(Engineering comments by Jeff Rice)

**ISSUE RECORD**

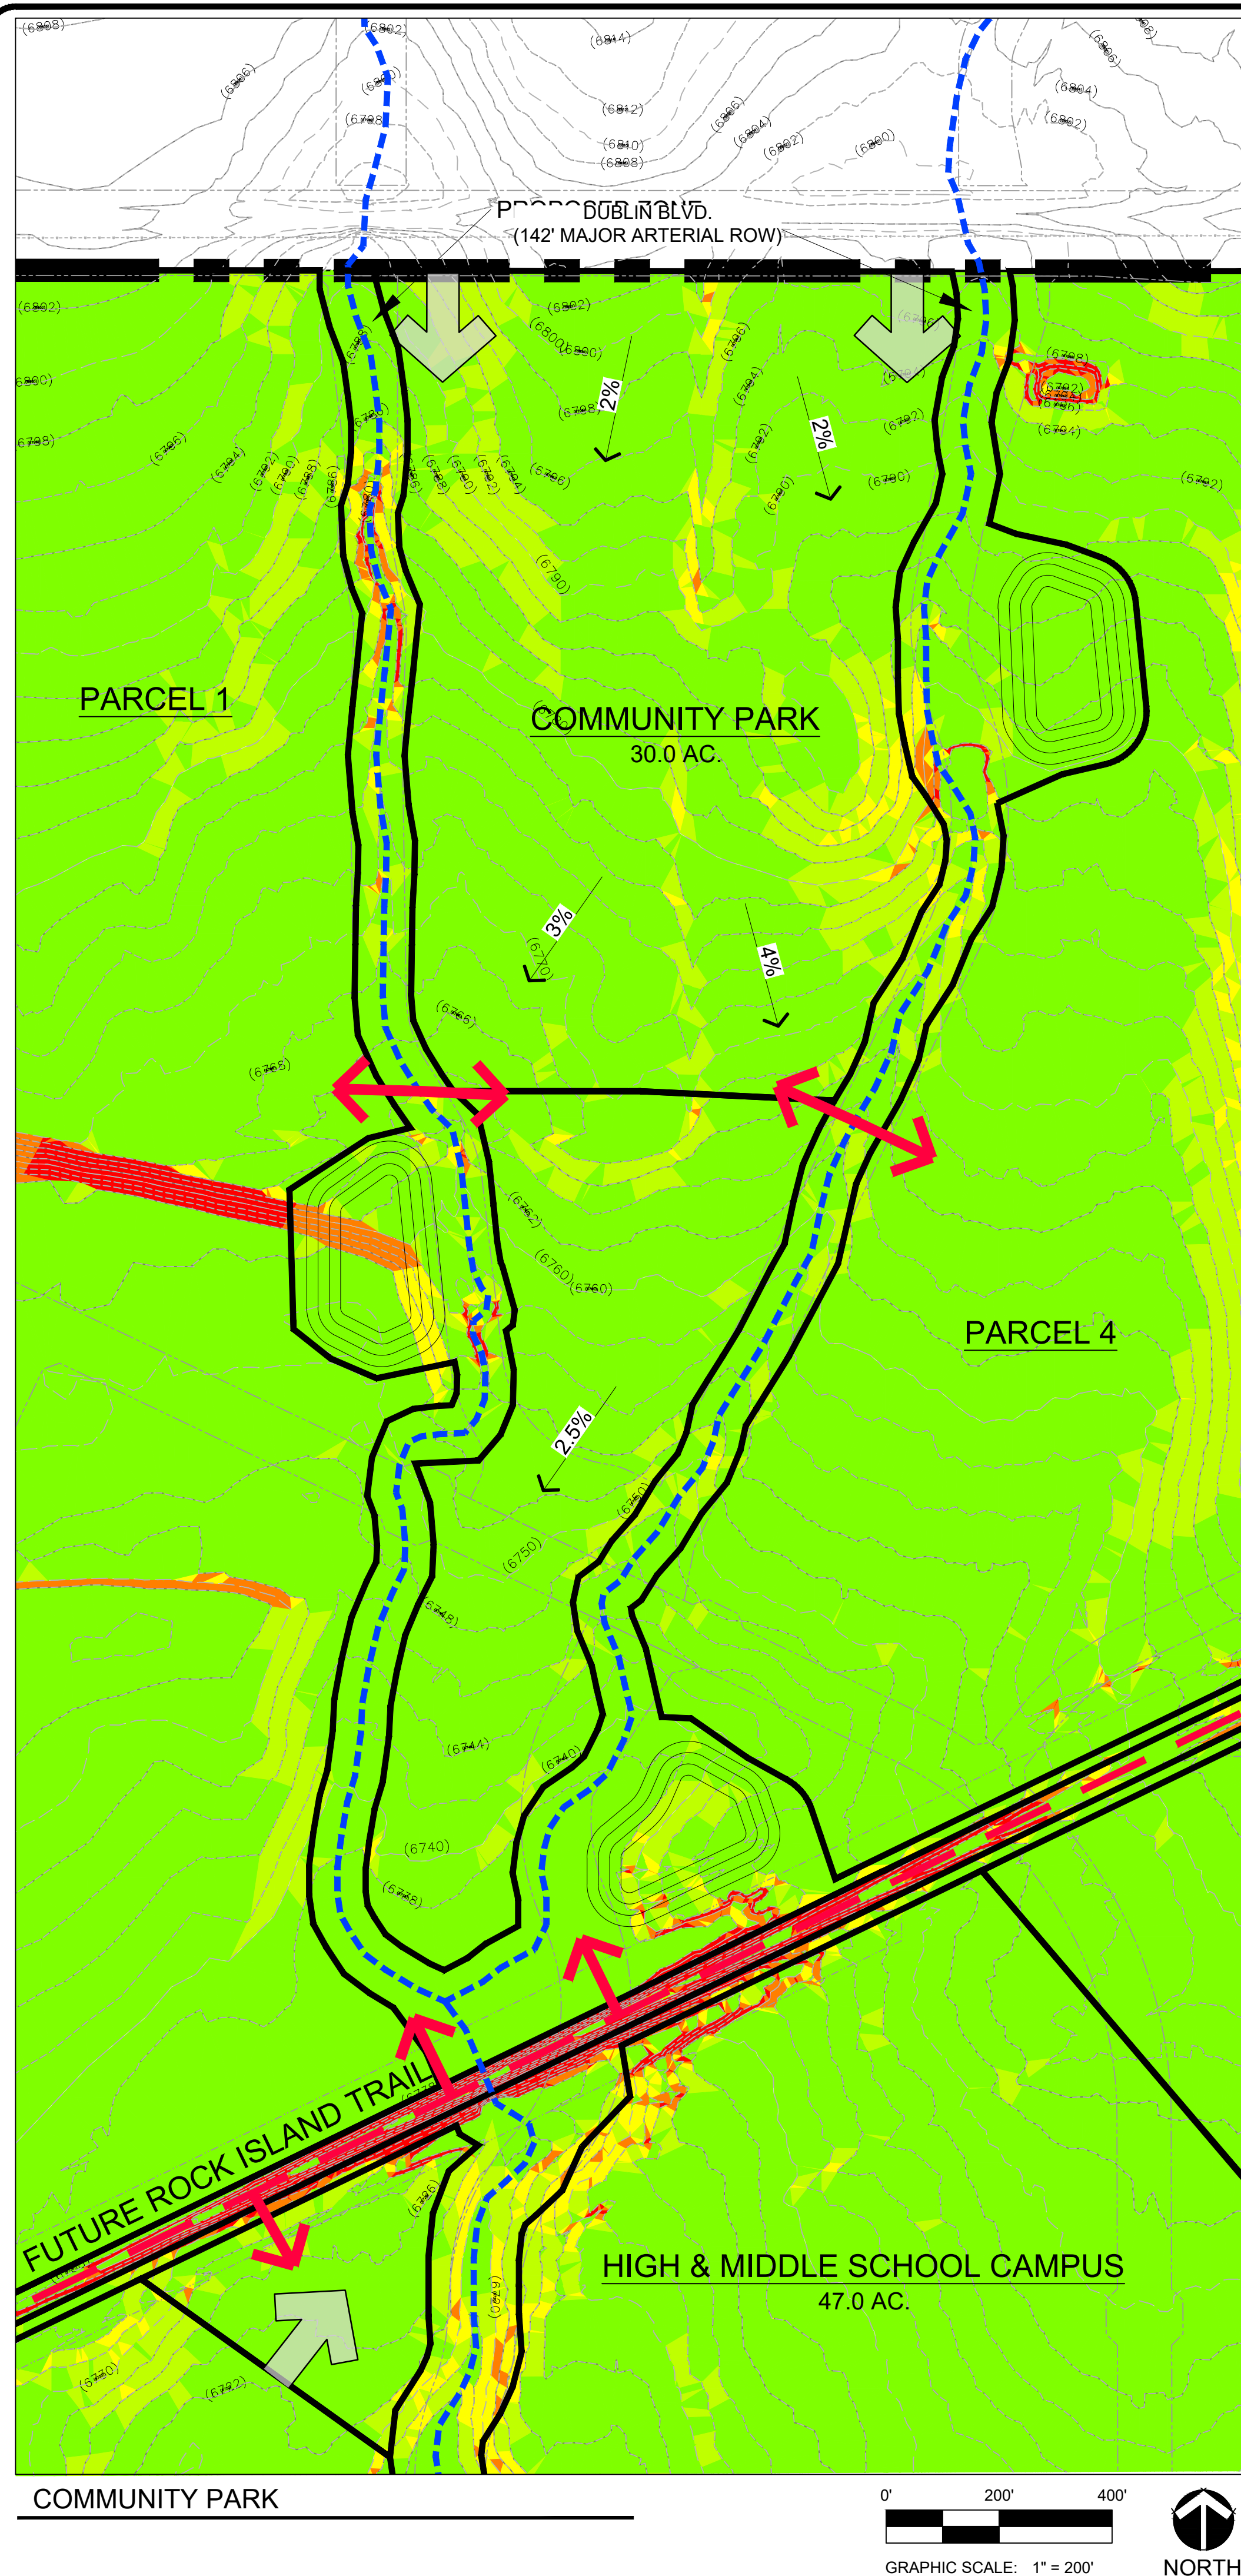
Why is ROW half of what is needed? (If Dublin is proposed to be split between incorporated and unincorporated areas, property acquisition from Falcon Highlands and EPC will be needed and County trail alignment (Rock Island and Falcon Hwy routes) in Tamlin Road ROW will need to be addressed.) (There was some coordination with Tim Roberts at the City in July 2022.)
